**STATE SIGNIFICANT
DEVELOPMENT
APPLICATION**

ADDENDUM

**VOL 5 – RESPONSE TO
PLANNING QUERIES**

25 MOSS VALE ROAD, BOMADERRY
JANUARY 2026 – UPDATE V3

# PROPOSED MOSS VALE RD EXPANSION

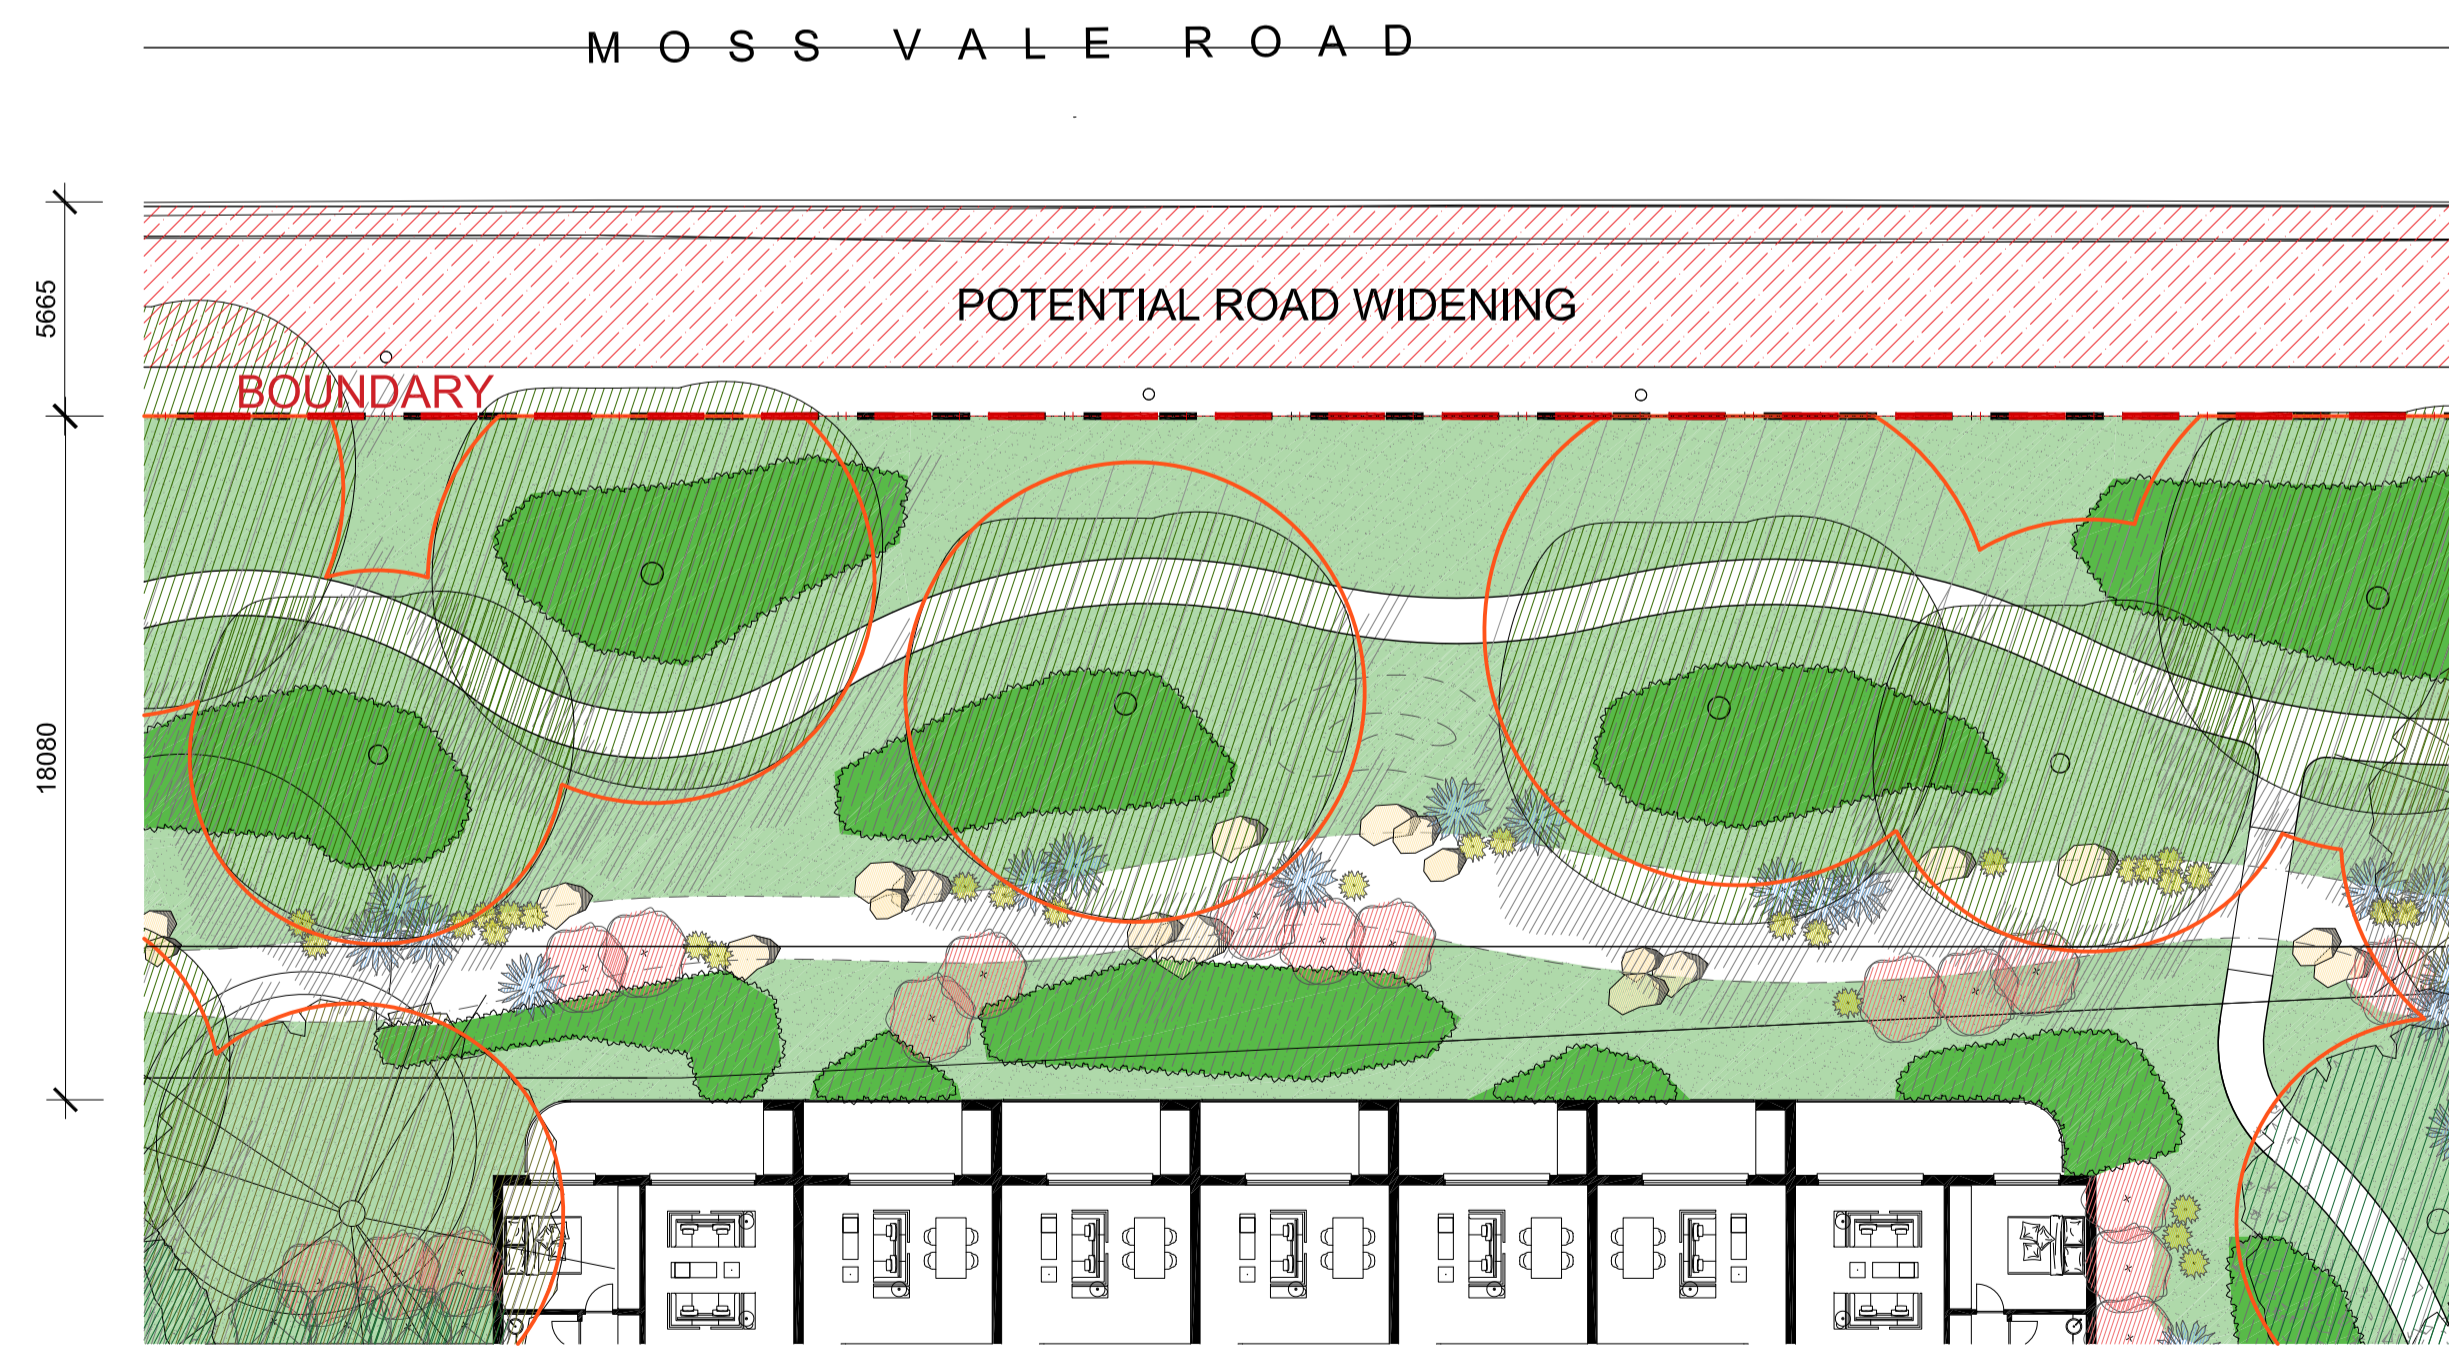
Moss Vale Road currently has a two-lane carriageway, with a carriageway width of approximately nine (9) metres in width, set within a road corridor that is forty (40) metres wide.

Currently the RTA has no formal plans for undertaking any road widening, and there is no land resumption planned or illustrated on any formal mapping of the site. As part of the discussions for the approved subdivision (SF10851) the Client consulted with the RTA. The RTA acknowledged that at some stage in the future there may be the requirement to widen Moss Vale Road to have two lanes in each direction, while also recognising that this was not either planned or budgeted for. As part of these discussions the RTA, Shoalhaven City Council, and Southern Cross Community Housing agreed to create a setback zone to Moss Vale Road to create flexibility for any future road widening.

It is not the area that the RTA will necessarily take for any road widening. We again note that the existing road corridor is 40 metres wide and there may not be the need for any additional land to be used above the existing width.

This zone, as illustrated in the drawings accompanying this SSDA submission, was intended to be the building setback line, while still allowing the requirements of a landscaped verge and buffer planting between the building and the road corridor.

A detailed cross section illustrating the proposed distance and landscape buffer treatments is shown below and included in the updated landscape package.
